**RE: Stack Short Plat
SP-22006 – Third Submittal**

Please refer to our responses below which address all review comments received from the City of Marysville on January 18th, 2023, regarding the Stack Short Plat submittal package. You will find the markup comments listed in the order that they were written followed by our response in *italics*.

STACK DESIGN & CONSTRUCTION, LLC
STACK SHORT PLAT
 PRELIMINARY WATER AND SEWER PLAN

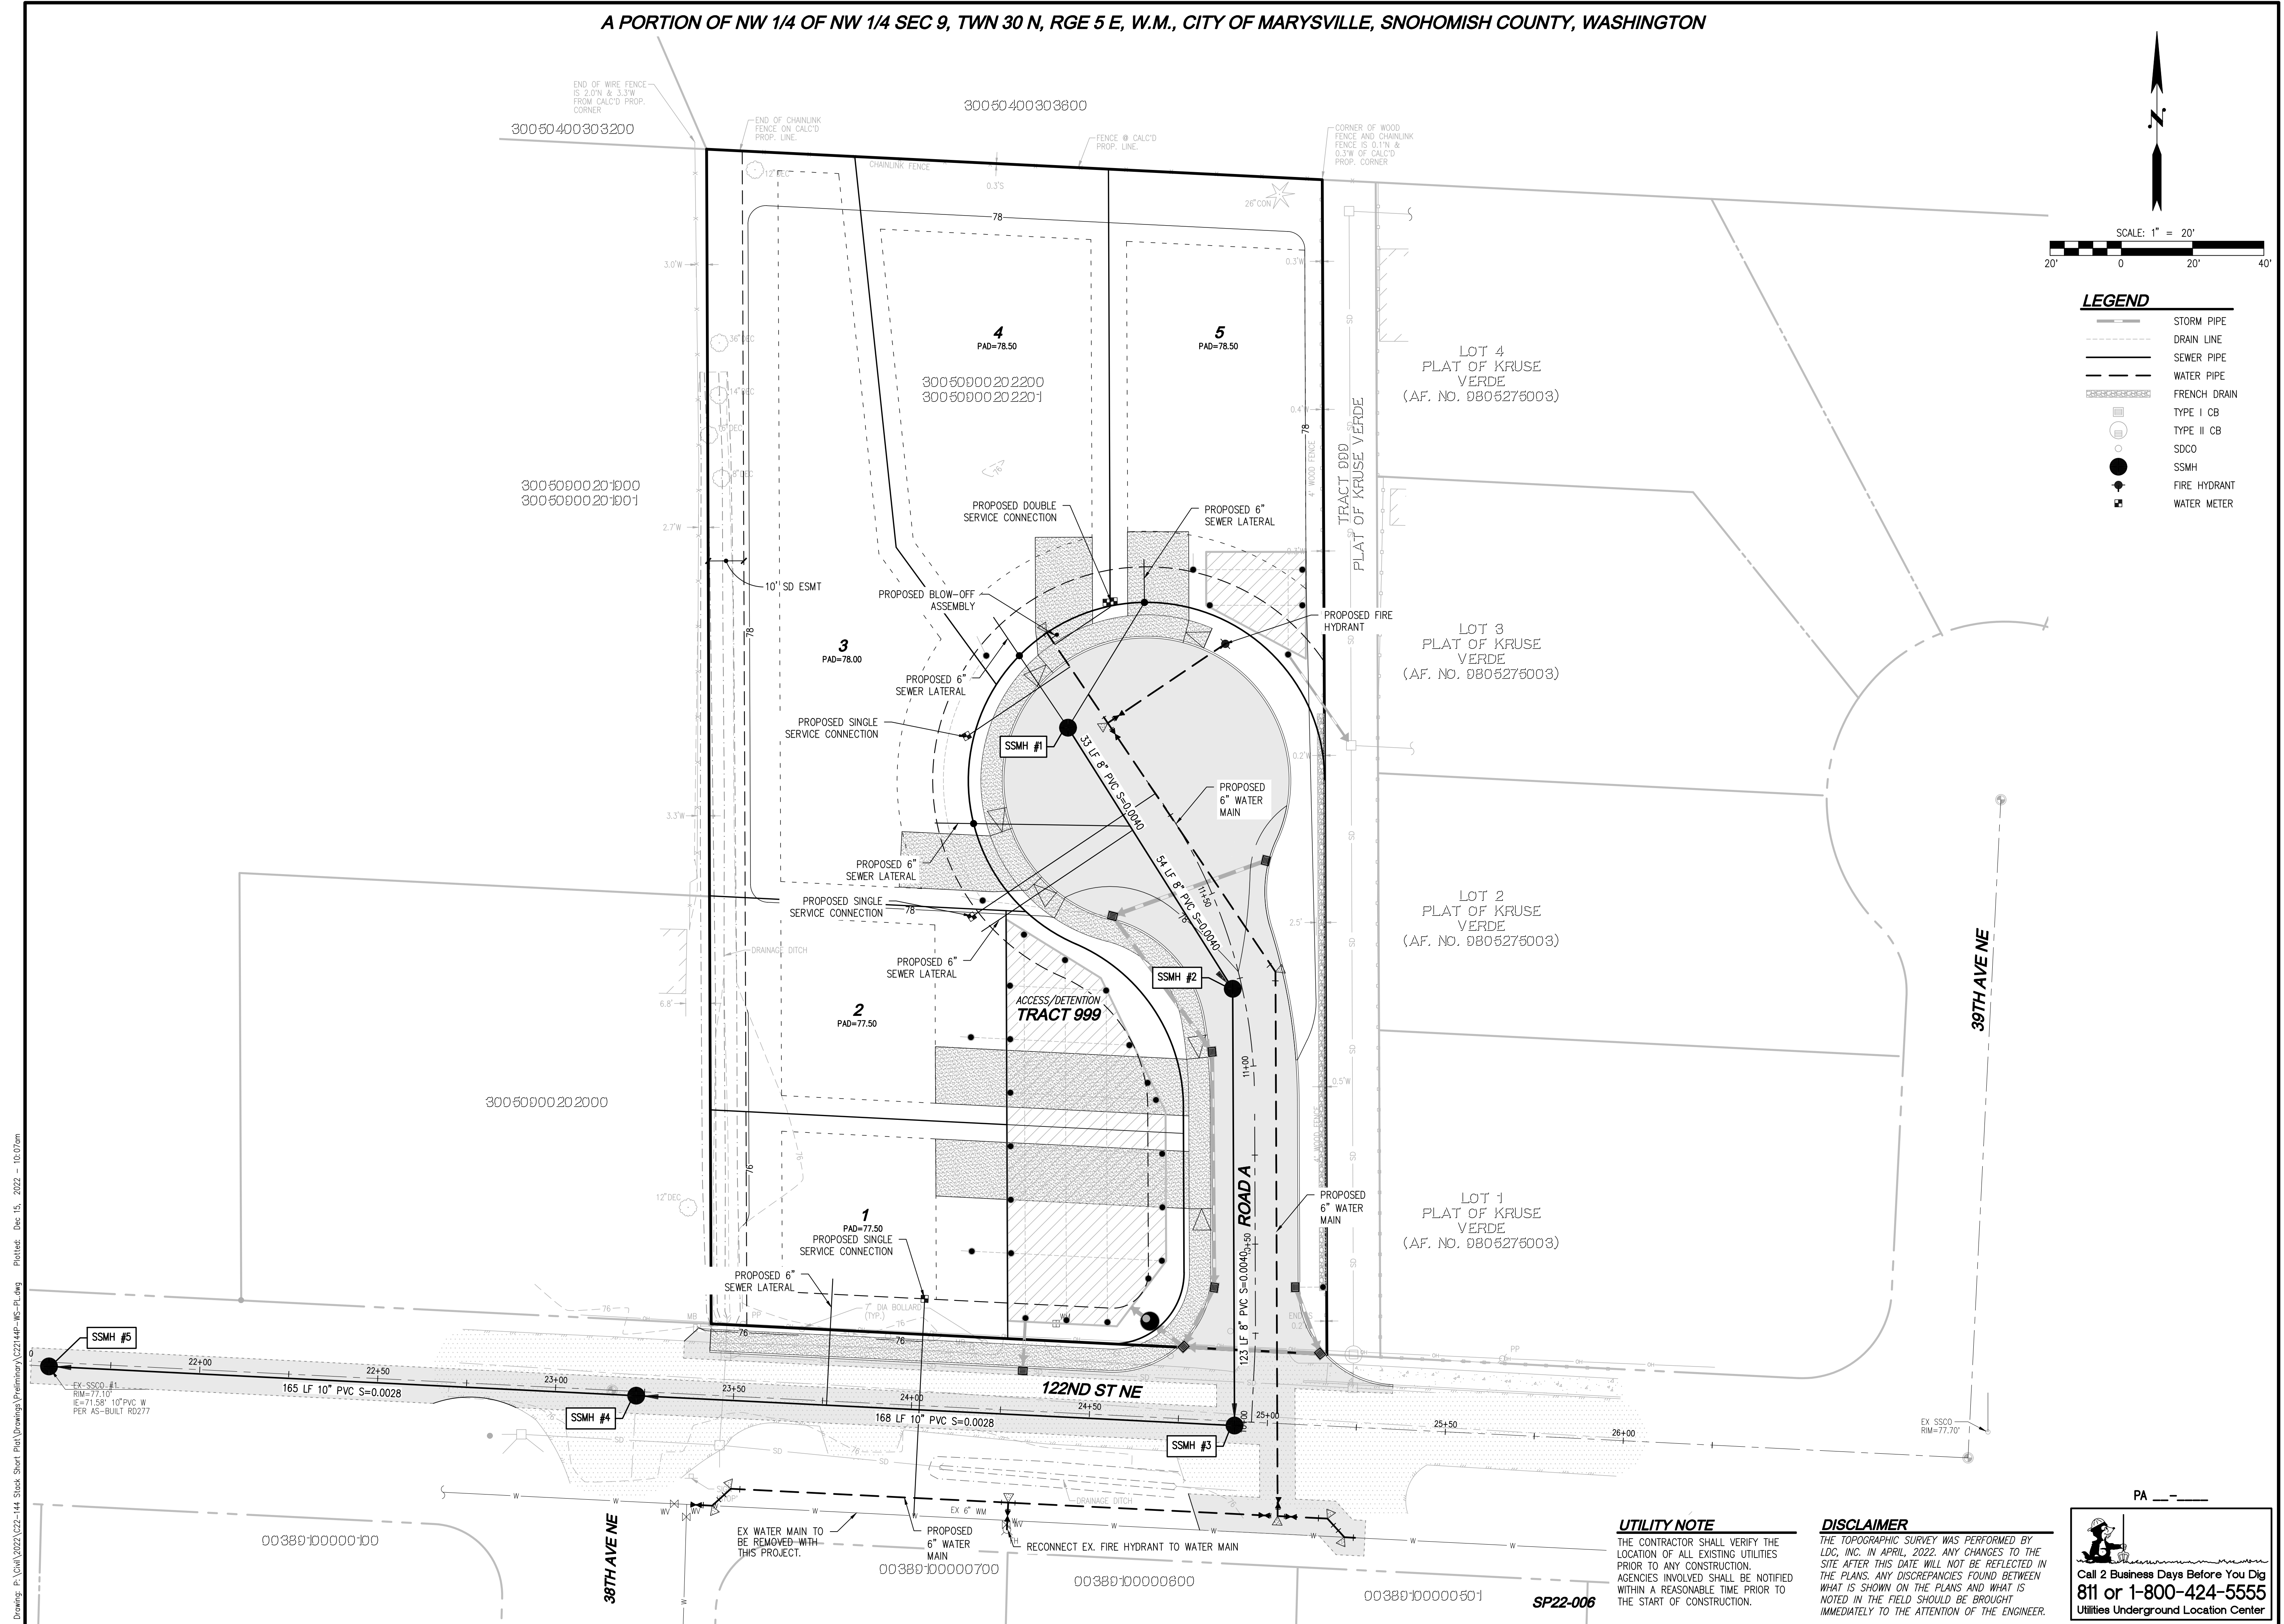
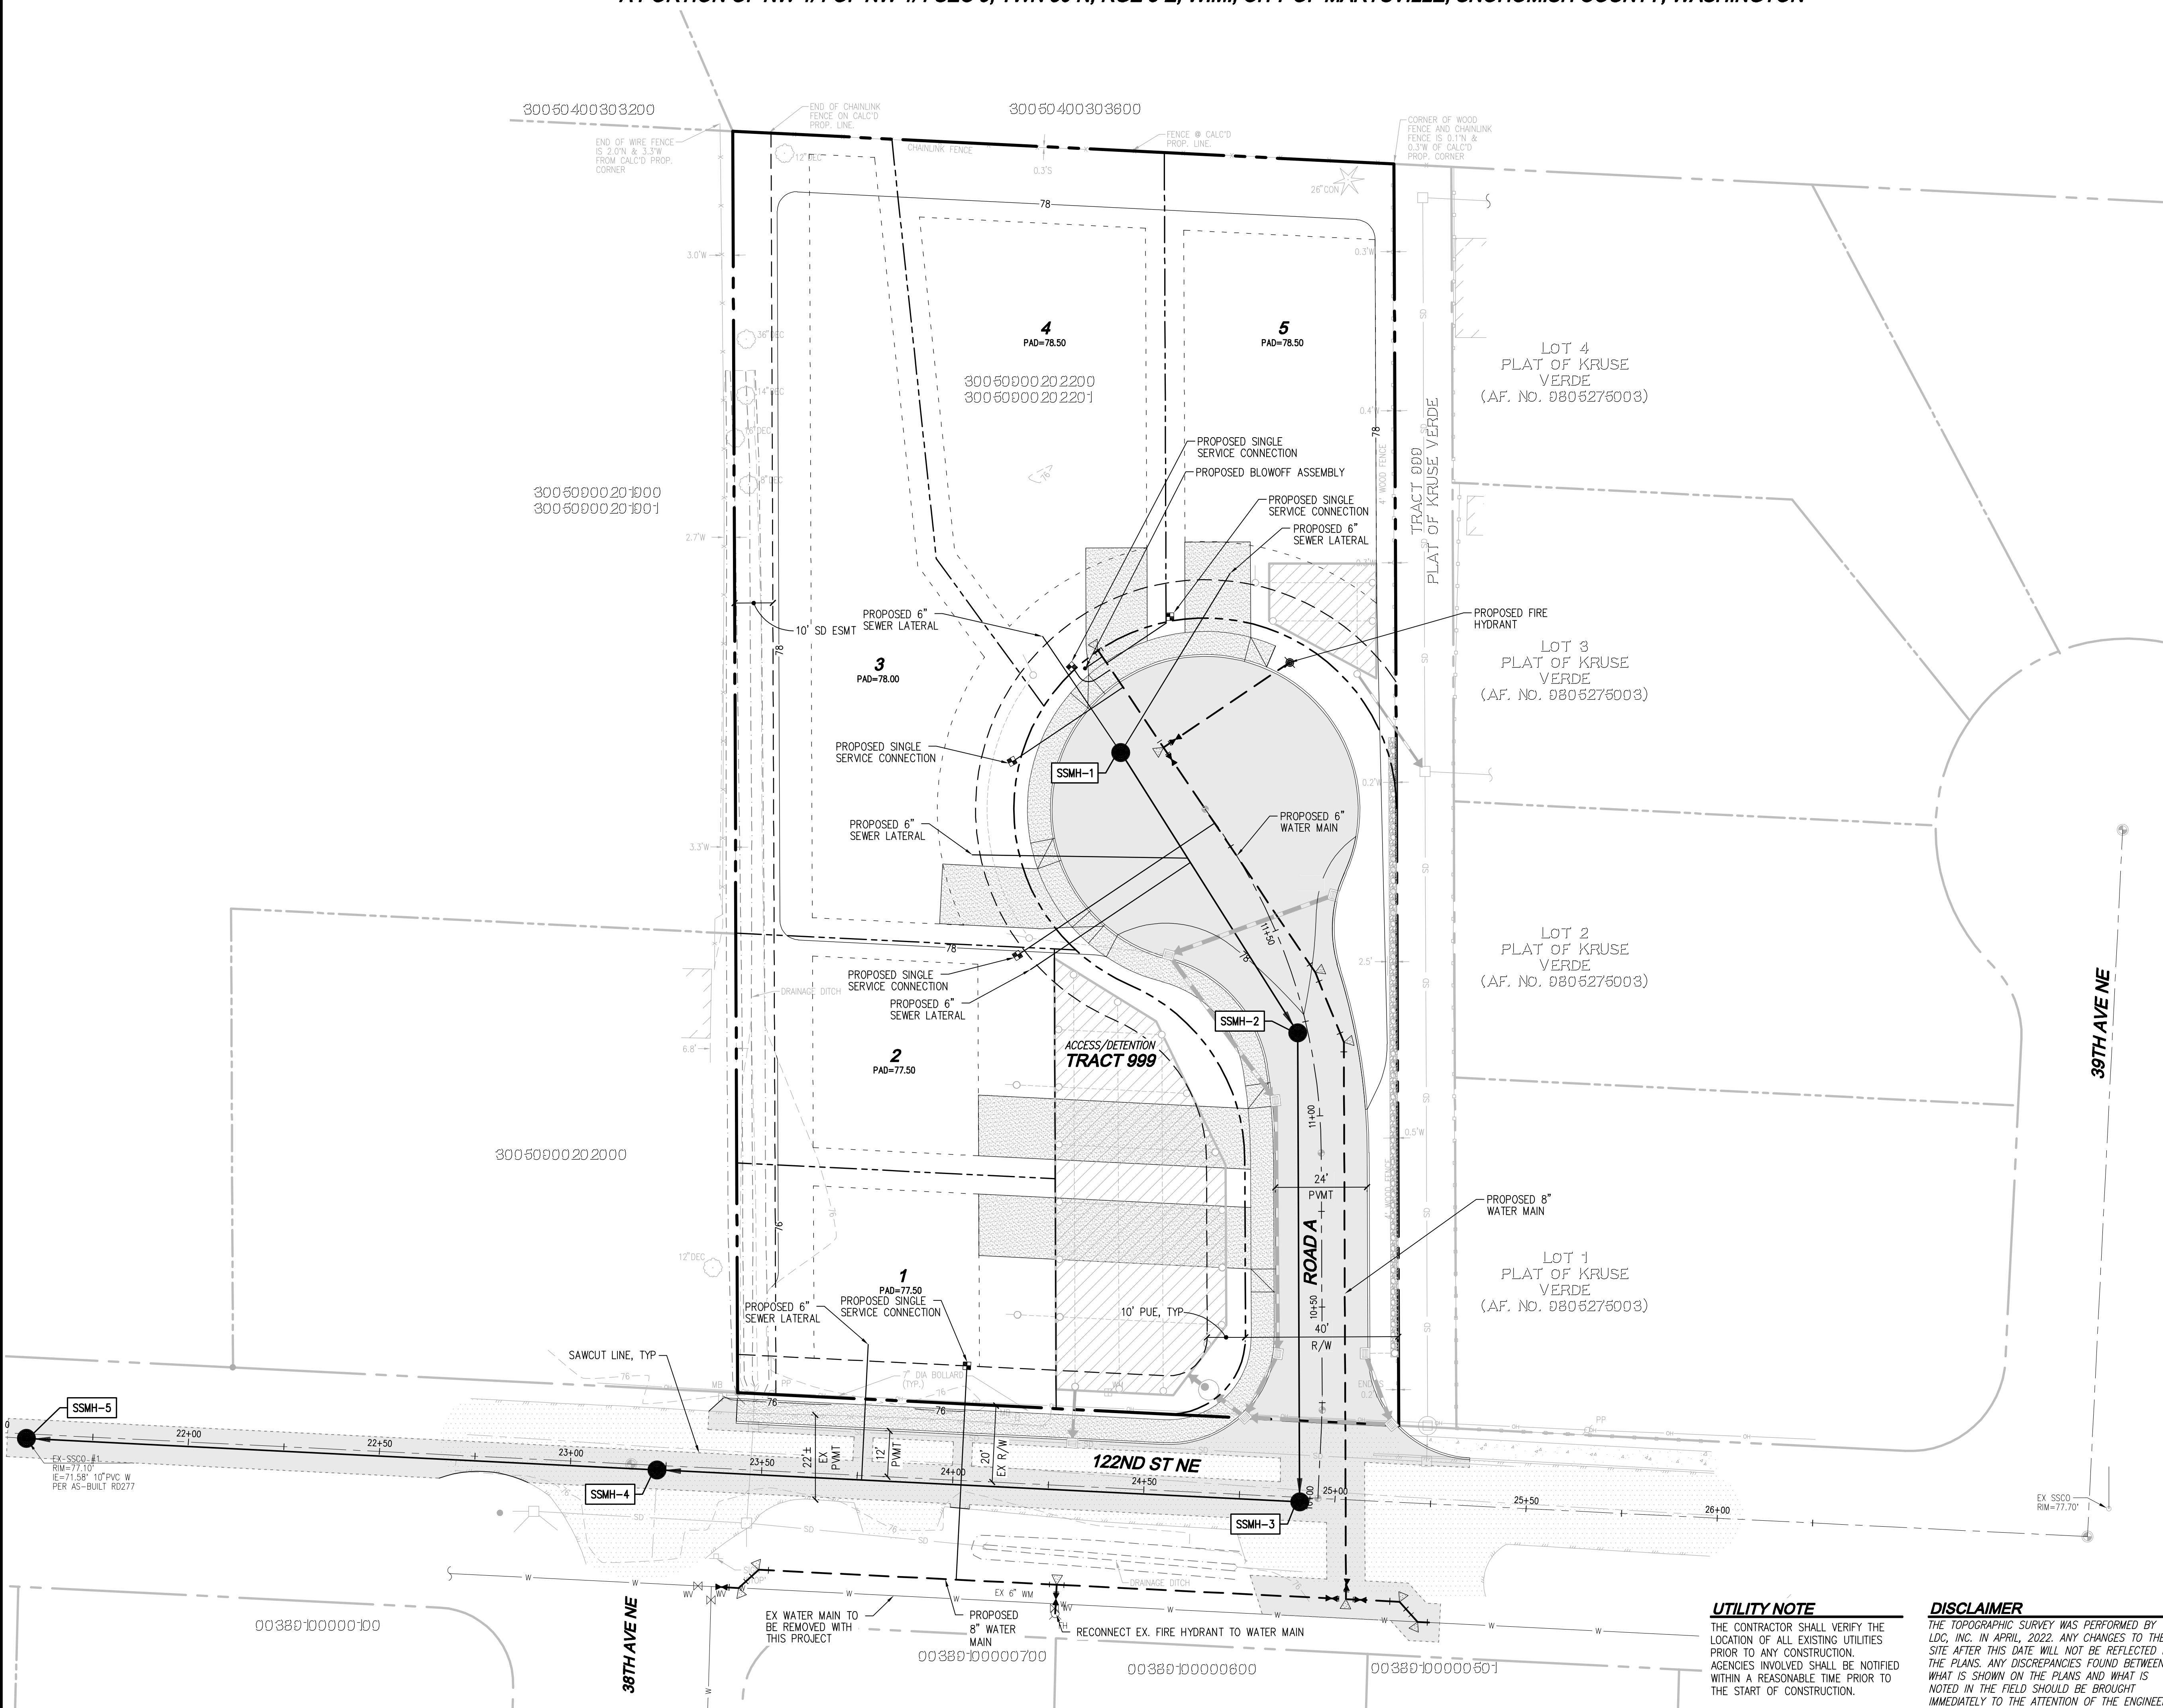
1. Proposed new water main installed is shown as 6". New water main should be 8" in accordance with Design and Construction Standards 2-050 Part B.

2. Proposed single service connection for Lot 1 is shown connected to old water main.

3. Design and Construction Standards 2-090 Part A states that all new connections should be single meter services. Suggest moving service line for Lot 4 to left side of driveway to allow for perpendicular connection to water main.

5. Replace proposed 6" water main going into plat with 8" water main in accordance with Design and Construction Standards 2-050 Part C.

Response: The main size was updated to 8".

Response: Please see the updated plans.

Response: See the revised water meter location

Response: The plans have been updated to show an 8" main.
